From: Sarah Burrow <Sarah.Burrow@arun.gov.uk>
Sent: 20 November 2019 15:47
To: Anita Gardner <Anita.Gardner@arun.gov.uk>
Cc: Planning.Responses <Planning.Responses@arun.gov.uk>
Subject: RE: Planning Consultation on A/161/19/DOC

APPLICATION NO: A/161/19/DOC

Site Address: Pound Place Roundstone Lane Angmering BN16 4AL

Description of Works: Approval of details reserved by condition imposed under ref A/9/19/PL relating to Condition Nos 3 - proposed surface water drainage and 16 - Construction & Environmental Management Plan.

DRAWING TITLE:
PROPOSED
DRAINAGE LAYOUT
SHEET 1 OF 3

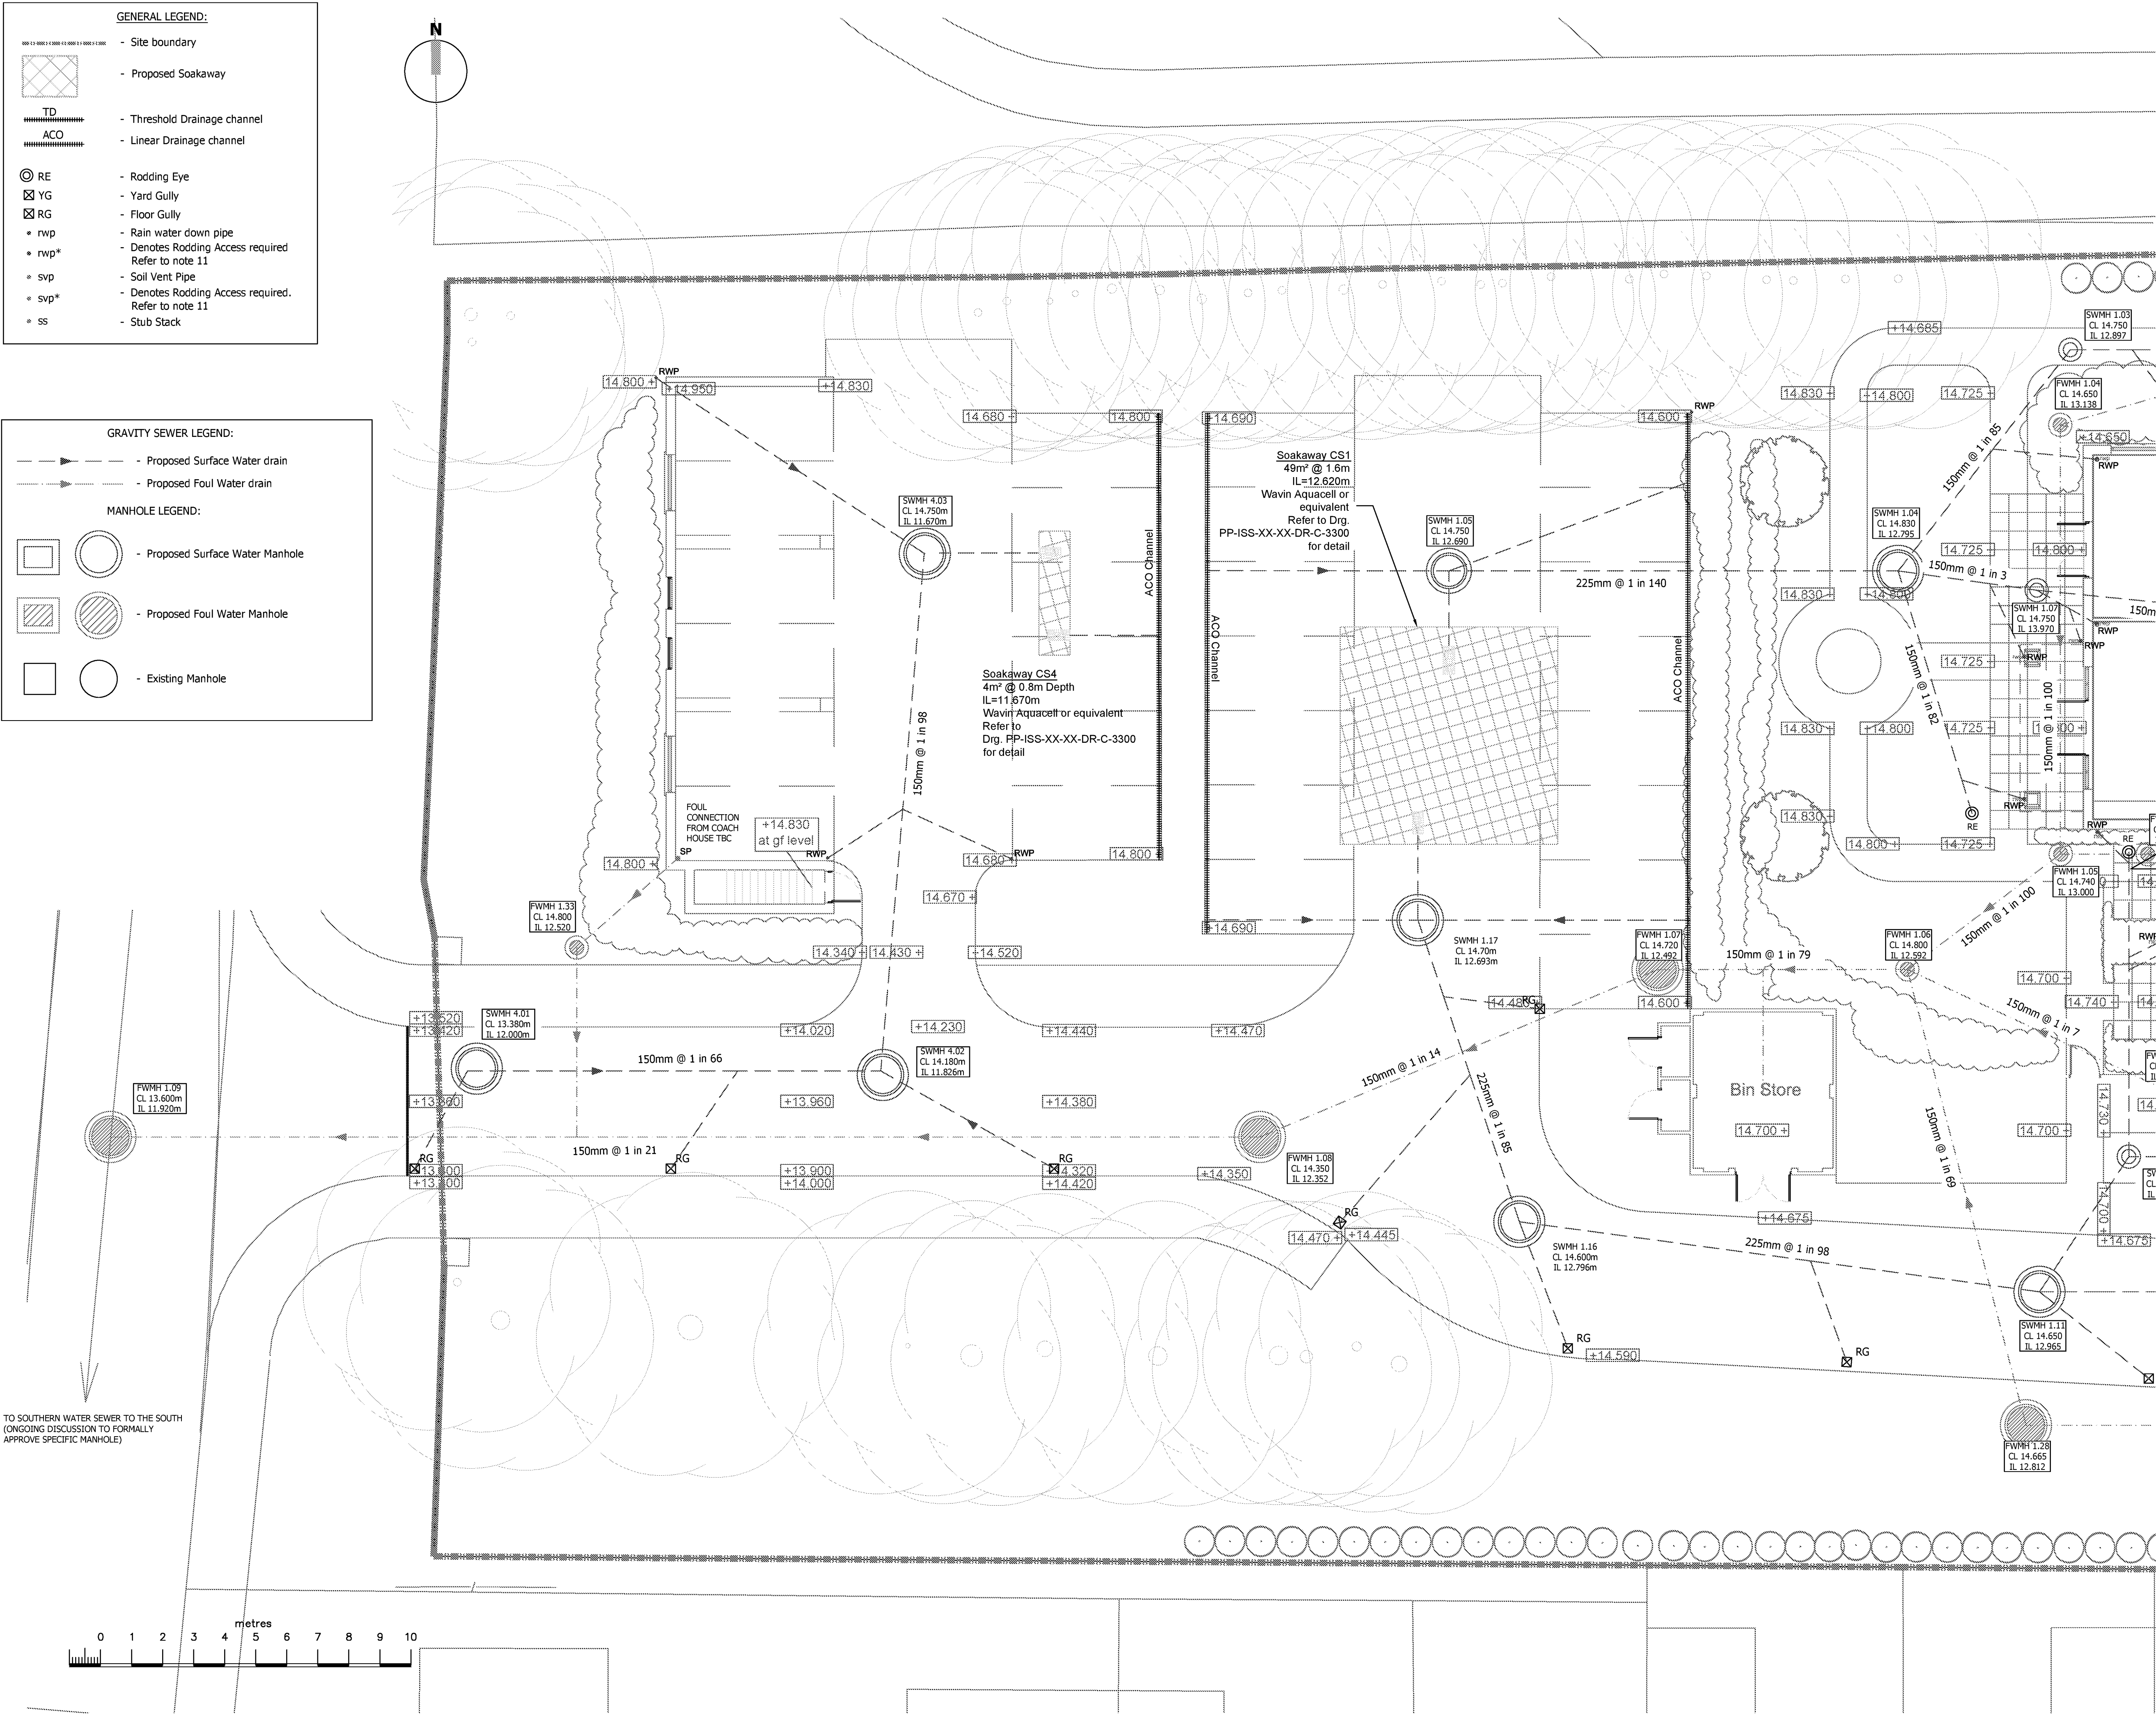
1. The proposed drainage plan in the Drainage Design Calculations differs significantly from the Drainage Layouts supplied. The number and locations of soakaways are different. Please clarify which plan is to be used and remove the other. If the calculations need to be amended for the Drainage Layout drawings please do so.

TYPICAL SURFACE WATER CATCHPIT CHAMBER DETAIL

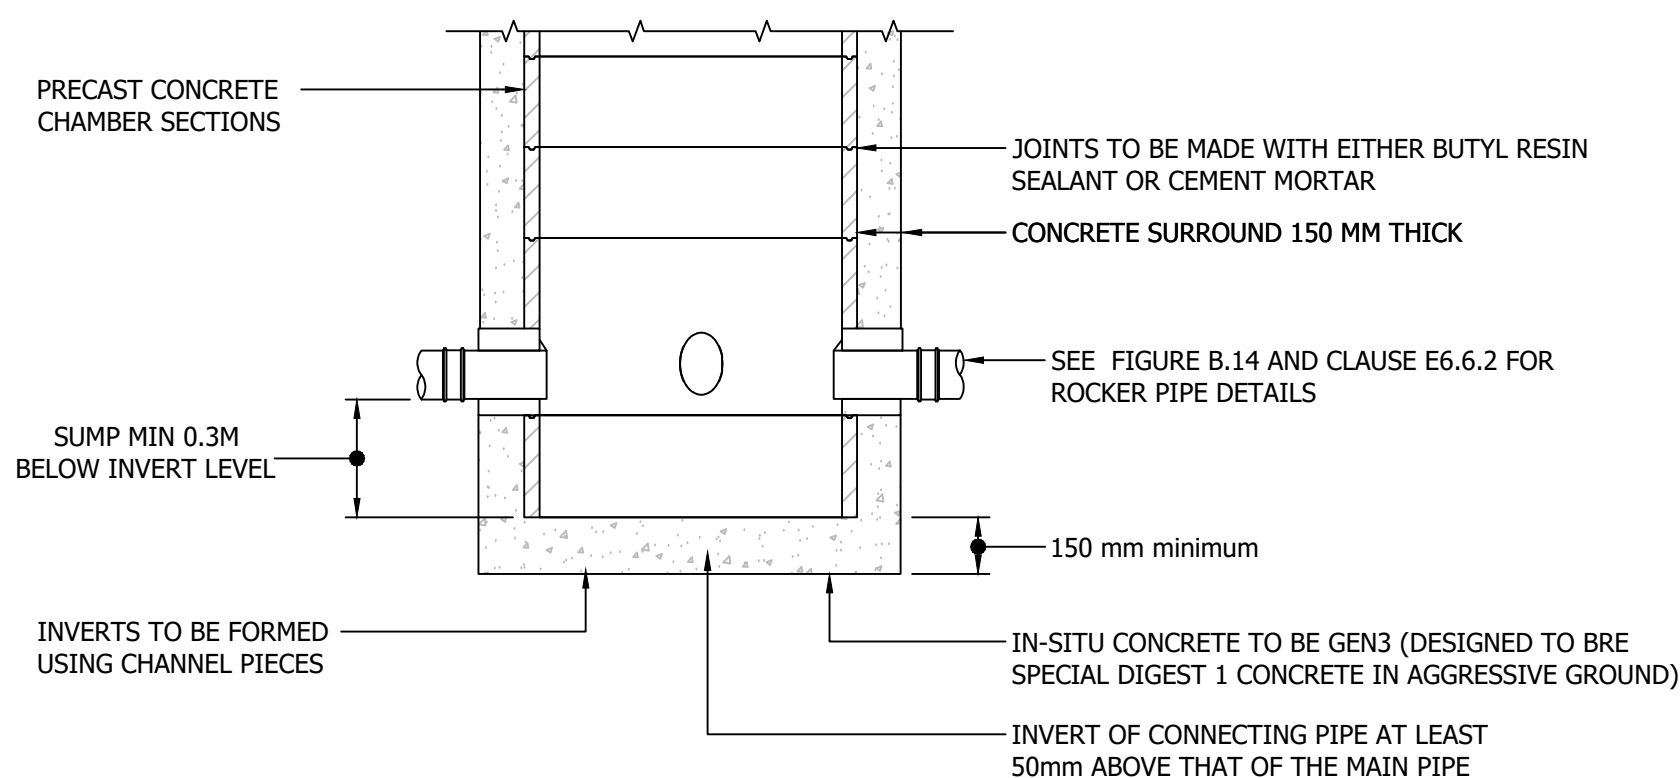
3. It is unclear as to whether or not permeable paving is to be used. In the Drainage Design Calculations permeable paving is referenced multiple times but this does not seem to be shown on the Drainage Layout drawings, or on the construction details. If permeable paving is to be used please clearly mark it on the layout drawings and include construction details for it. If not please amend the Calculations and provide justification for the change in strategy.
